Our ref: Jindera Battery Energy Storage System (SSD-68815961)

Subject: Request for Additional Information

I refer to the assessment of Jindera Battery Energy Storage System (SSD-68815961). After careful consideration, the Department is requesting that you provide additional information.

RIGHT TURN
Union Rd, Wagga Rd
& Urana Rd

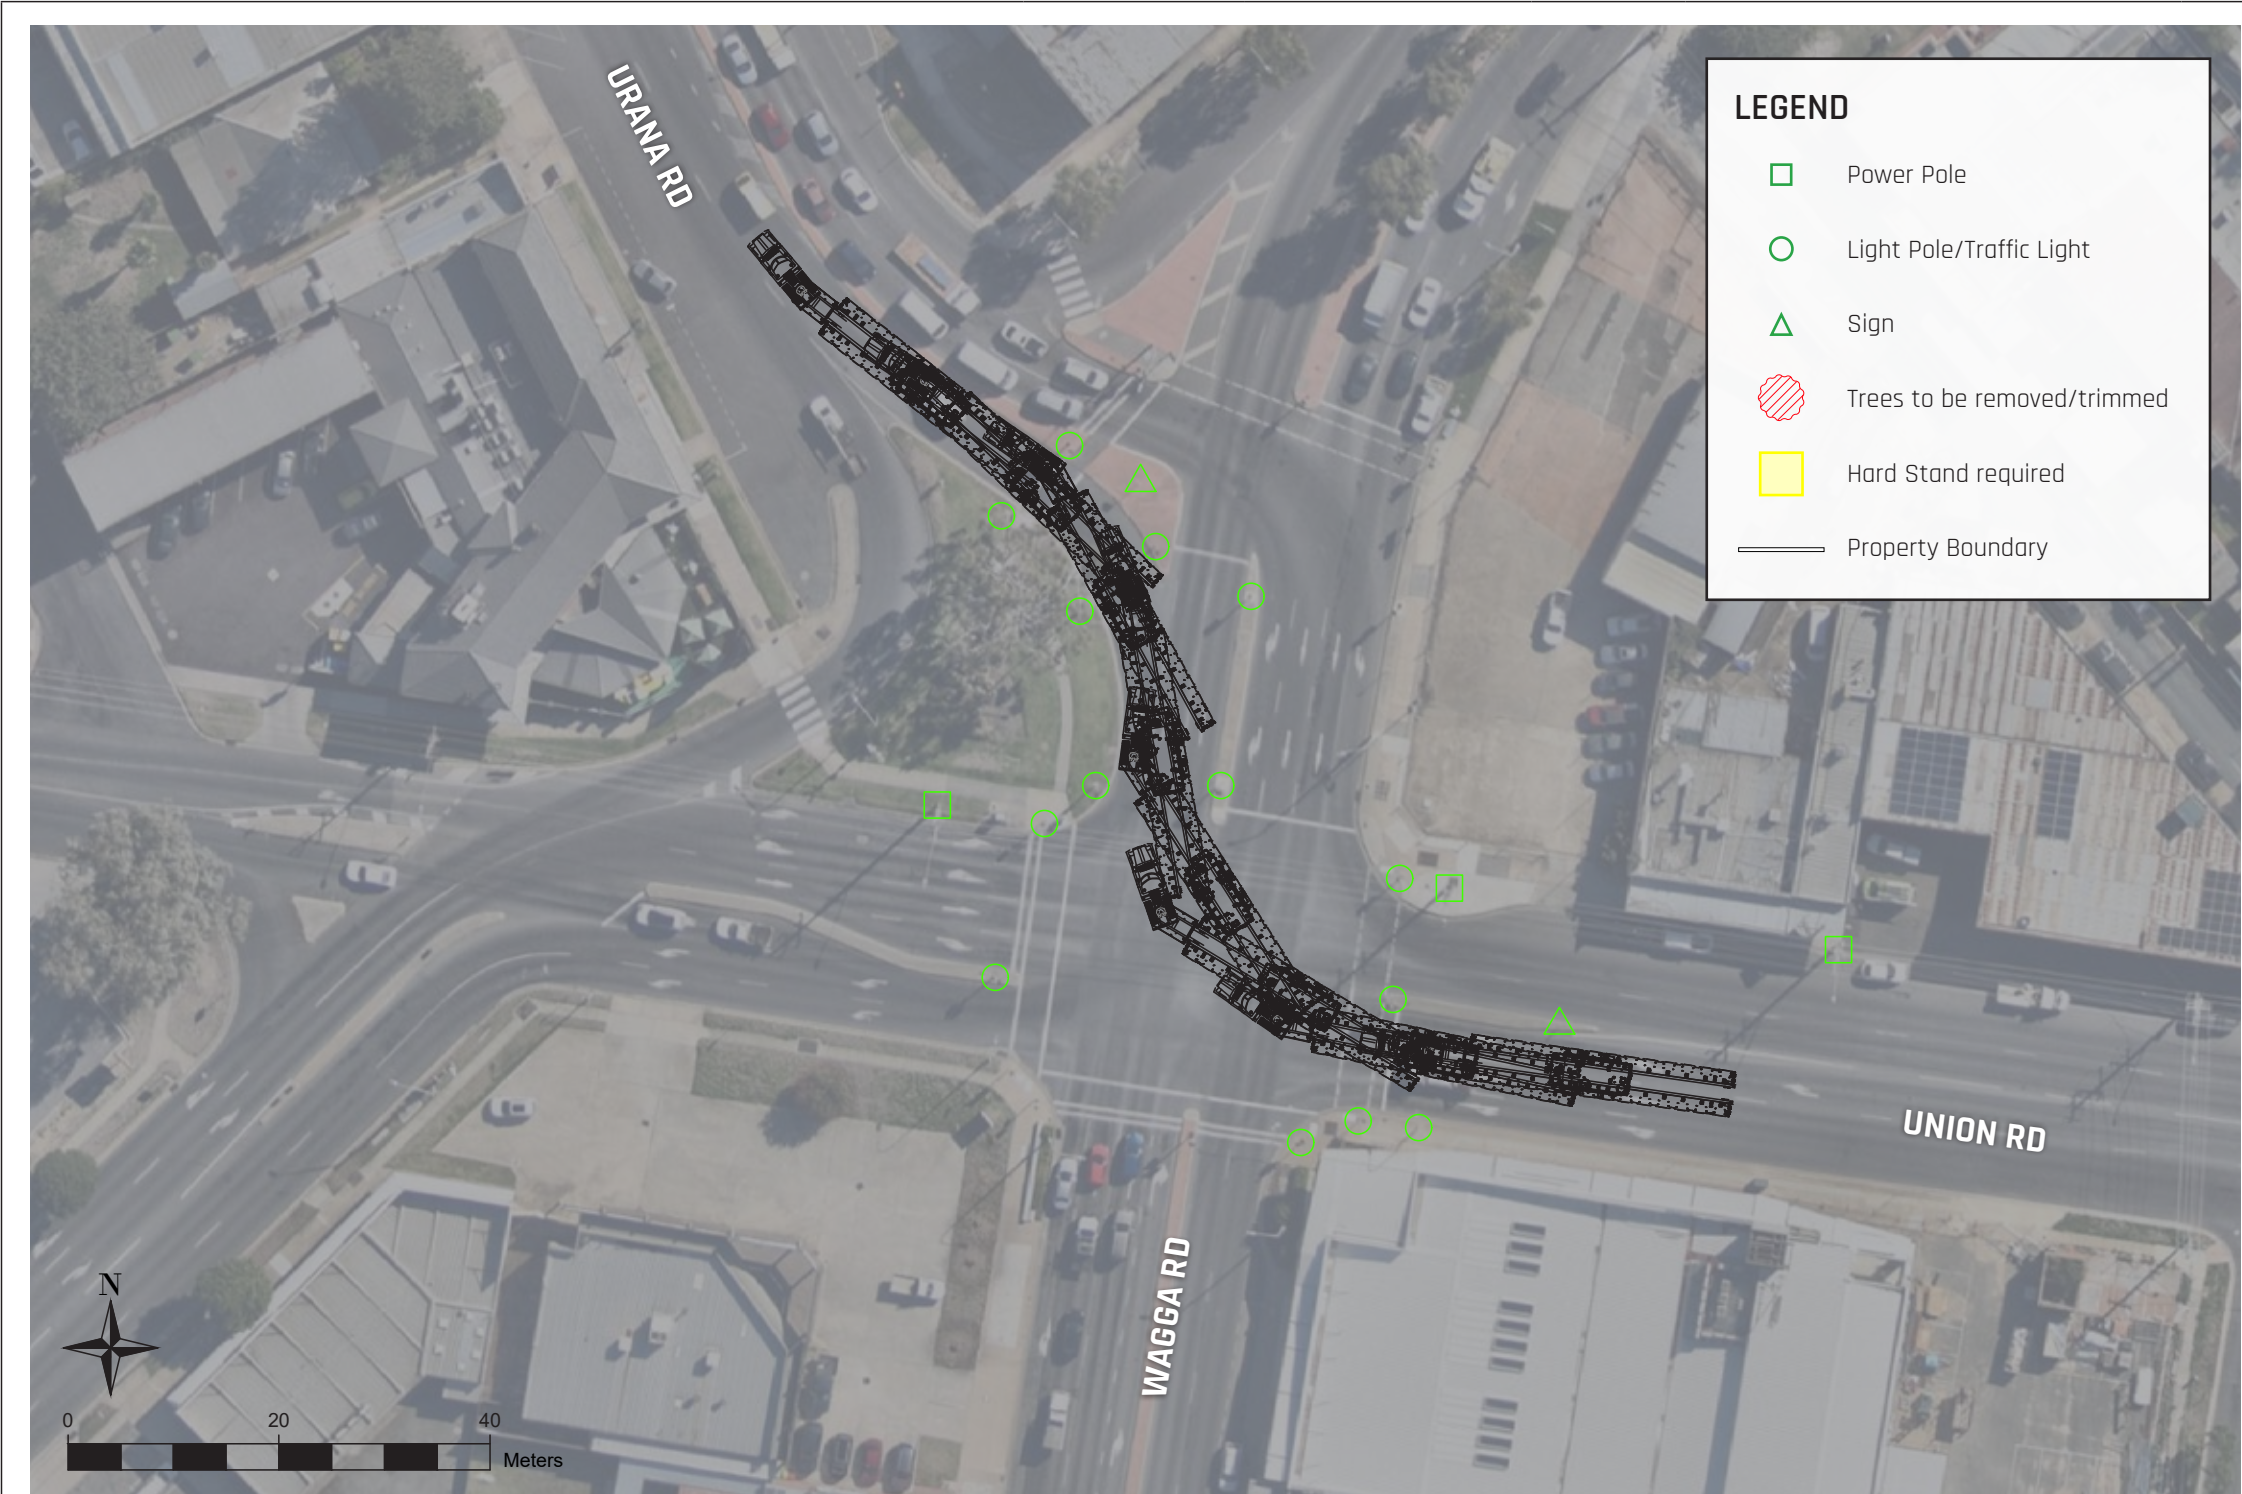
- swept path analysis for the segment of the proposed haulage route for oversize overmass vehicles between Young Street, Albury and Urana Road, North Albury;
